**From:** David Senus <dsenus@woodardcurran.com>  
**To:** Jean Fraser <JF@portlandmaine.gov>  
**CC:** "Barbara Barhydt (bab@portlandmaine.gov)" <bab@portlandmaine.gov>, "DMP@...  
**Date:** 5/23/2014 9:50 AM  
**Subject:** RE: 97 Cumberland Ave. - Stormwater/Traffic Memo

RE: Proposed Multi---family building located at 97 Cumberland Ave  
Hi Jean:

Based on the May 19, 2014 Response to Comments letter prepared by Sebago Technics, the majority of the comments contained in our memo dated May 5, 2014 will be addressed by the Applicant as part of future submittals; however, a significant comment that remains to be resolved is Comment #6:

INFILTRATION POND
NOT TO SCALE

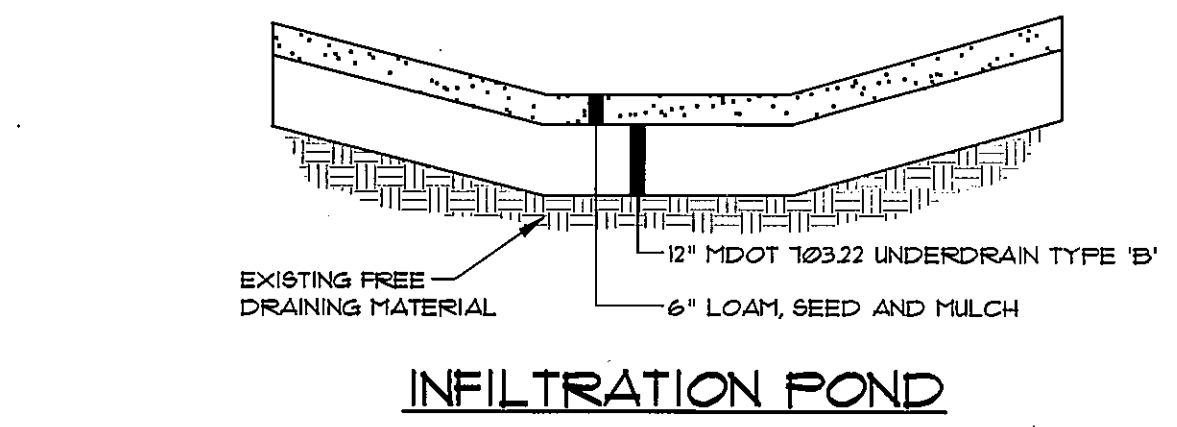
6) The Applicant proposes a rip-rap spillway to manage overflow from the proposed infiltration basin. Overflow from this spillway will drain west, below a stockade fence, across a fenced dumpster area on the 7-Eleven property, and across the 7-Eleven parking lot to the Washington Avenue drainage collection system. The applicant notes that this route is similar to the pre-development drainage pattern (existing condition); however, a review of the HydroCAD model indicates that more area will be directed to this location in the post-development condition, and although the infiltration basin will provide minor detention, the model predicts an increase in runoff rate at this location (from the spillway) in the postdevelopment 10- and 25-year storm events. The drainage design should be revisited to eliminate directing overflow onto the neighboring property, unless the Applicant obtains drainage easements from N/F Ginn Portland LLC and modifies the adjacent fence and dumpster/parking area to accommodate drainage from the site. The Applicant should propose an alternative means of managing overflows from the infiltration basin. The Applicant has responded by stating that the increase in flow is not substantial (0.01 CFS), that there are no viable storm drain connection options in the area, and that it is "(their) belief that the developer of 7-Eleven took into account the offsite drainage at that time" (when the 7-Eleven site was developed). Although we would agree that the increase in the modeled flow rate is insignificant, the plan indicates that all of the flow will be directed to a specific, and different location (from the existing condition) on the neighboring property. This requires approval and accommodations from the neighboring property per 14-526 (b) 3. Water Quality, Stormwater Management and Erosion Control, and per the Flooding Standard contained in Section 5 of the Technical Standards. The Applicant needs to demonstrate that appropriate measures are in place on the neighboring property to accommodate stormwater flow across this property, and that they have approval in the form of an easement from the 7-Eleven property owner to convey drainage onto and across their property at this specific location.
